# Preferred Project Report

& Response to Submissions  
Cabarita Mixed Use Proposal MP 07\_0179

## **Preferred Project Report – Section 75H of the EP&A Act, 1979**

### **Mixed Use Development at Cabarita Beach/Bogangar - MP 07\_0179**

SCALE:	DATE:	CHECKED:
1:200 @A1	10.12.07	AP
PROJECT NUMBER:	DRAWING NUMBER:	ISSUE:
07-040	DA.13	C

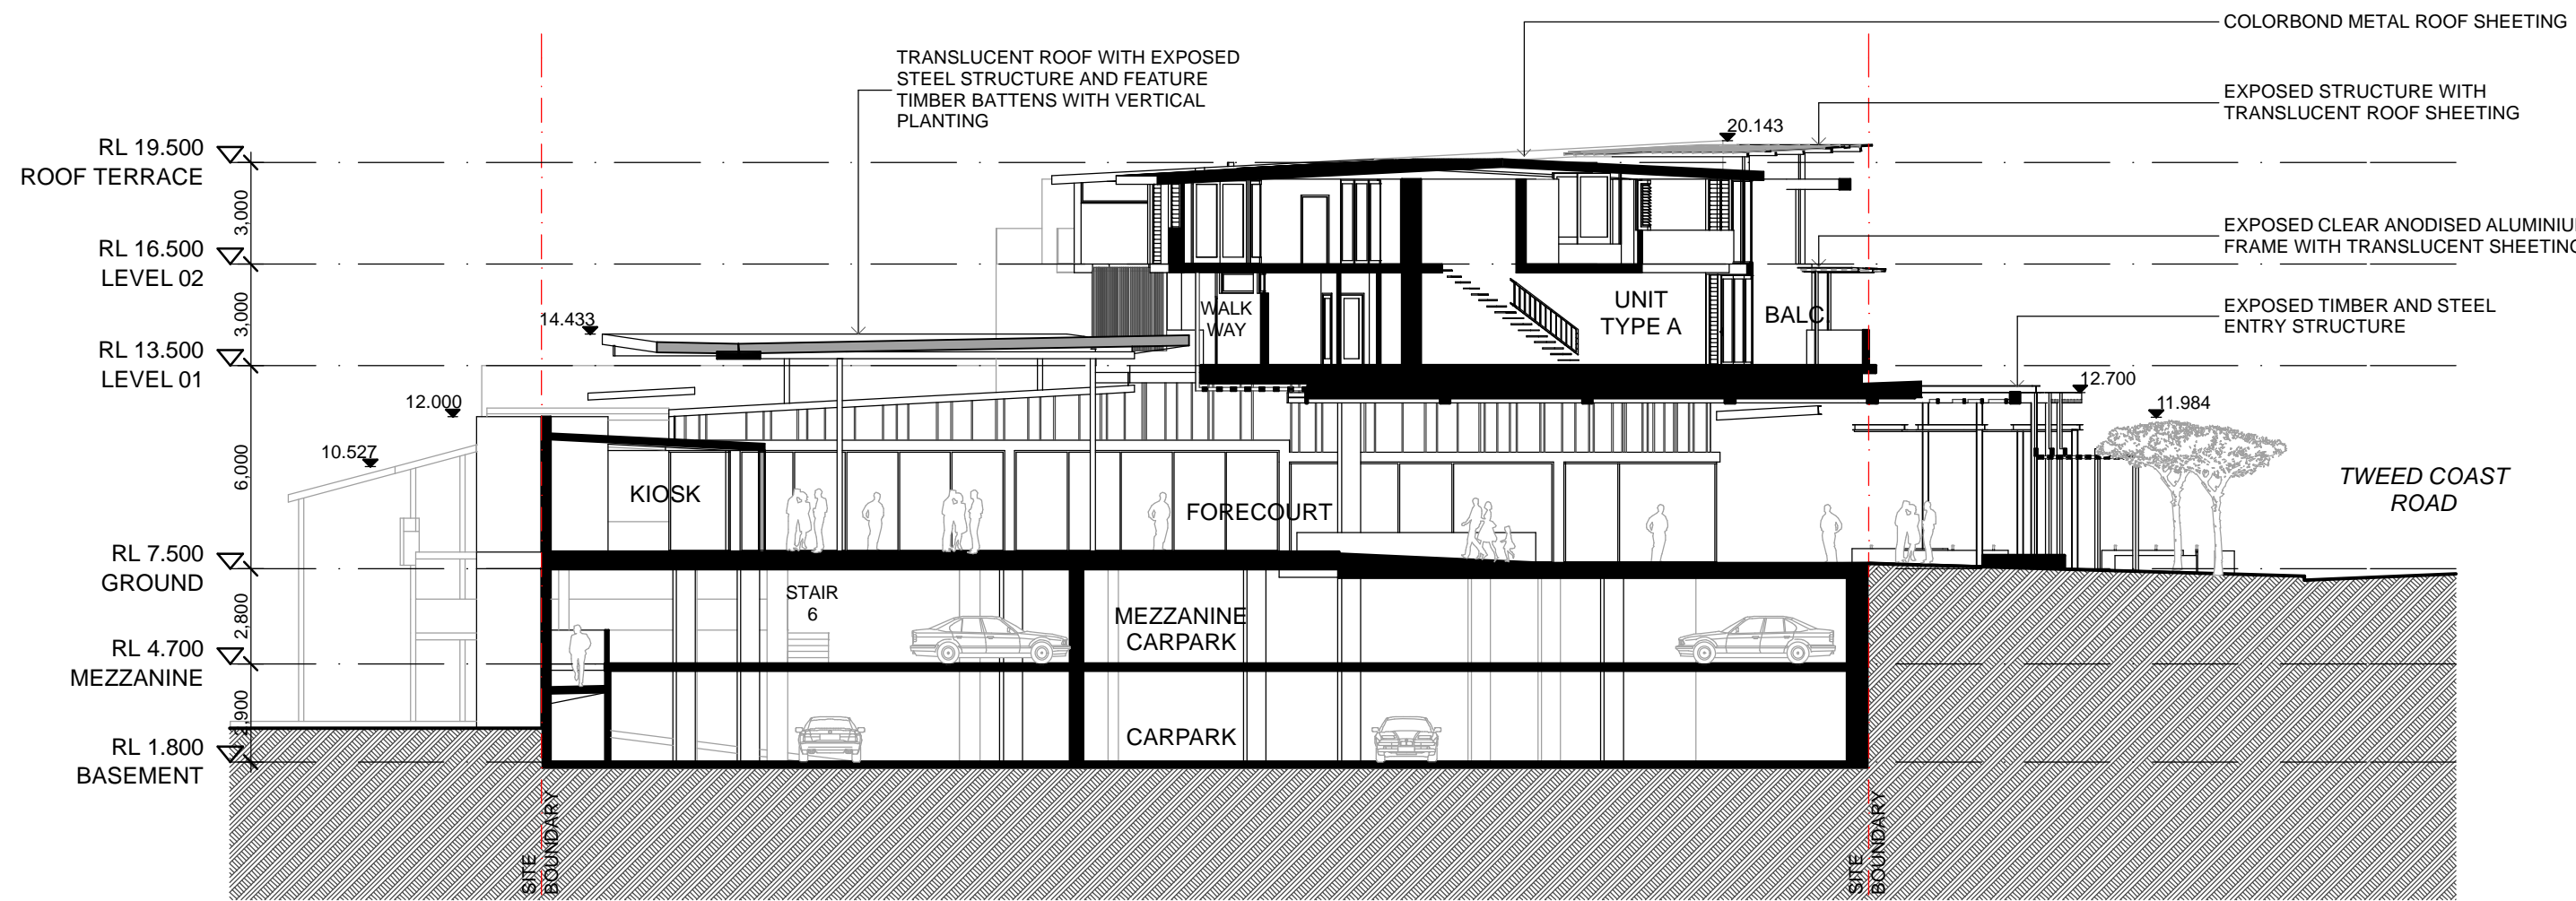
- a) Service vehicle access – *The project blocks safe service vehicle access to the rear of No.47 Tweed Coast Road and Lots 188, 189, 190 in DP 259164 along Hastings Road. The project is to be amended to facilitate appropriate 24 hour unrestricted service vehicle access to these properties. The amended scheme must demonstrate that there is sufficient space for large truck to enter and exit the site in a forward direction (using truck turning path templates), and guarantee a manageable long term solution to this issue.*

Safe service vehicle access has now been facilitated for the rear of No 47 Tweed Coast Road as shown in amended Plan DA-13 G. The 6mtr wide laneway for service vehicles has been continued through the development providing continuous access to Hasting Road.

Plan DA-13 Revision G identifies the 6mtr wide laneway at the rear of Lots 188, 189 & 190 in DP 259164. The proposed development has been relocated by 3mtrs from the adjoining rear boundary to facilitate the continuation of the laneway.

A 24 hour unrestricted 6mtr wide access easement through the "at grade" carpark on Hastings Road will connect the laneway with Hastings Road. This easement will be dedicated to Tweed Shire Council and remain on Title until proposed laneway has been constructed.
